**MODIFICATION      REQUEST:      Hume  
Highway - Woomargama Bypass**

**(08\_0237 MOD1)**

***Modification to permit increased flooding  
inundation levels associated with the bridging  
of Mountain Creek***

August 2011

Drawing No. NBI 1038-510-SK-DR-0006 Rev E

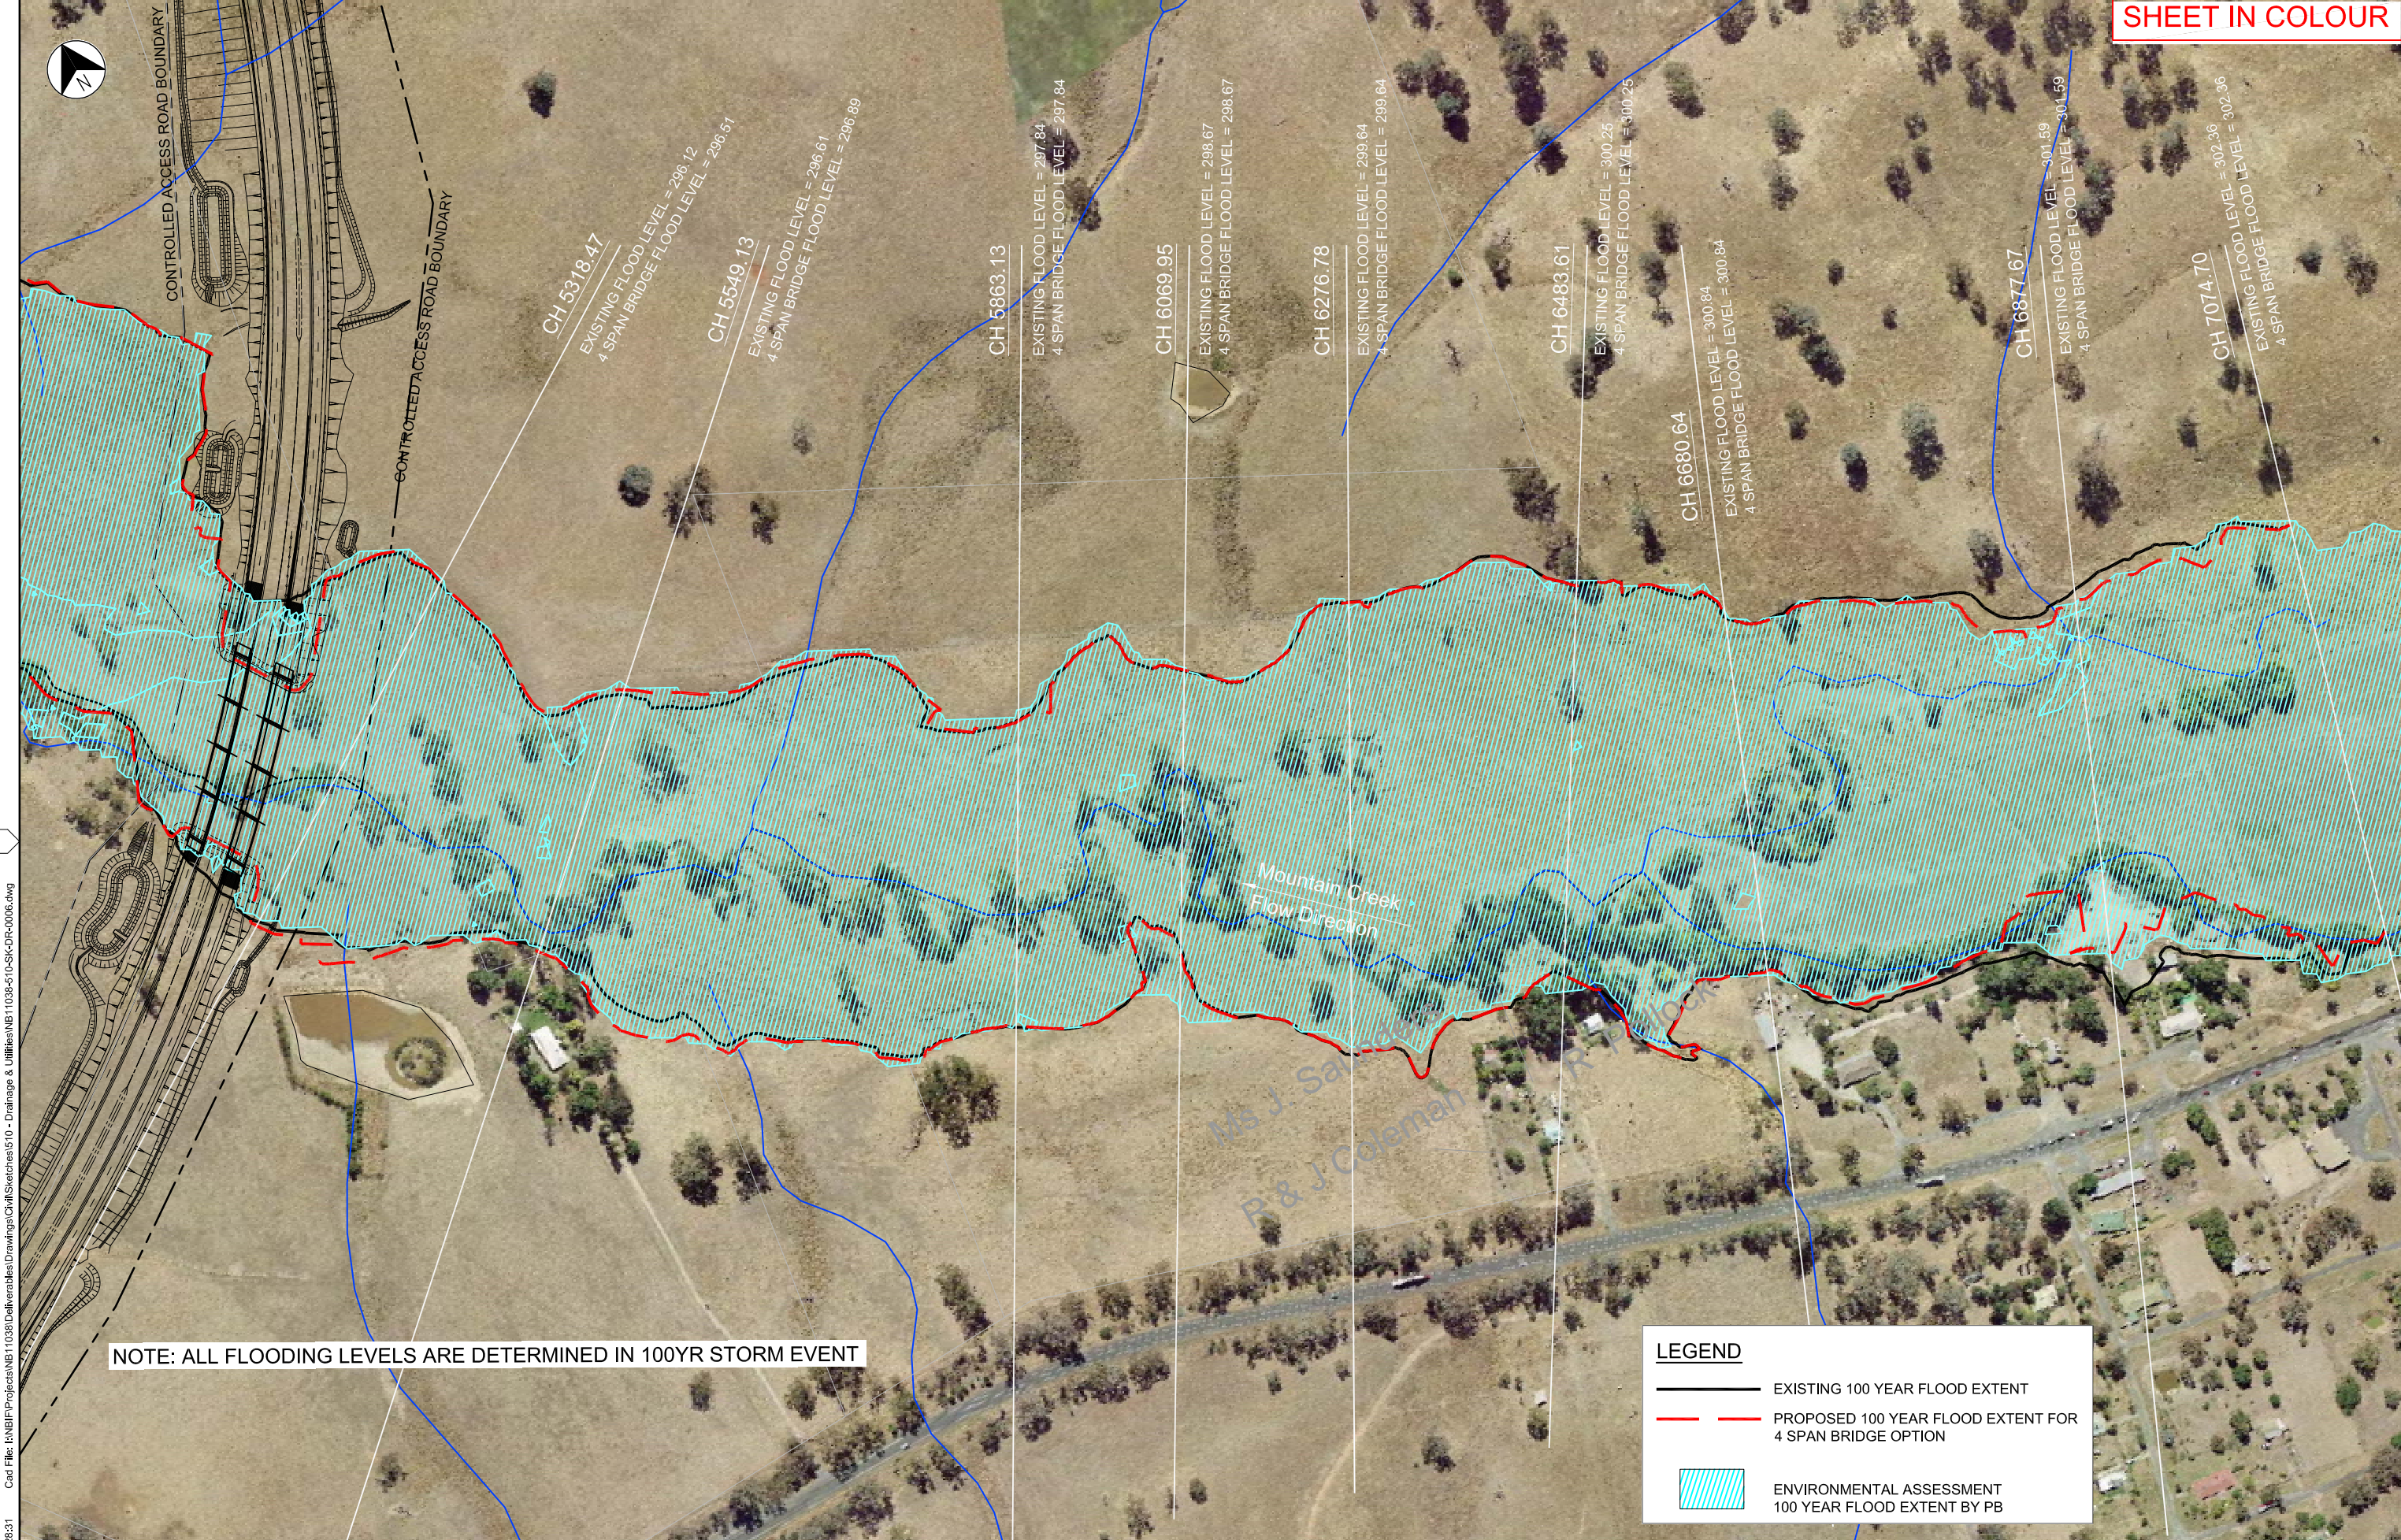
Notwithstanding conditions 2.25 and 2.26 the detailed design of the new Hume Highway bridges at Mountain Creek shall limit to the greatest extent practicable increases in flooding impacts between the bridges and a point 600 metres upstream of the bridges to those shown on Drawing No. NB11038-SK-DR-0006 Rev E.

The proposed four span bridge results in a maximum afflux of approximately 480mm approximately 200 metres upstream, reducing to zero approximately 500 metres upstream. The flooding impacts remain wholly contained within the floodplain. At the location where afflux is greatest the width of the flow would marginally increase from 180 metres to 190 metres and the greatest increase in width of flow would be 25 metres at approximately 300 metres upstream (see Figure 2).

The impact of the flooding is the primary issue for consideration. Modelling shows increases of up to 0.48m for the four span bridge option compared to existing conditions. In addition, near the bridge where floods level and extents increase, the time period which the existing 1 in 100 year flood is exceeded would be about six hours, both of which are significantly higher than the levels provided for in condition 2.25. However, about 600 metres upstream of the bridge, the hydrographs of the existing and four span bridges are identical.

Notwithstanding, this increased flooding impact will be confined to the existing floodplain area, with the width of the flood extent increasing by up to 25 metres approximately 300 metres upstream of the bridge. The Department is satisfied that this increase in width is minor in the context of the overall flooding impact, as is evidenced by Figure 2. Further, the flooding impact is contained to land that is owned by the RTA and is unable to be substantially developed in the future as it is zoned rural (as advised by Greater Hume Shire Council in accordance with Holbrook Interim Development Order 1970). The Department is satisfied that there would be no adverse impacts as a result of the relatively minor flooding changes due to the land being zoned rural, and the absence of any dwelling or other structure in the affected area.

- 2.26A Notwithstanding condition 2.25 the detailed design of the bridges at Mountain Creek shall limit to the greatest extent practicable, increases in flooding characteristics between the bridges and a point 600 metres upstream of the bridges to those identified in modification request 08\_0237 MOD1 and in particular shown on Drawing No. NB11038-SK-DR-0006 Rev E.
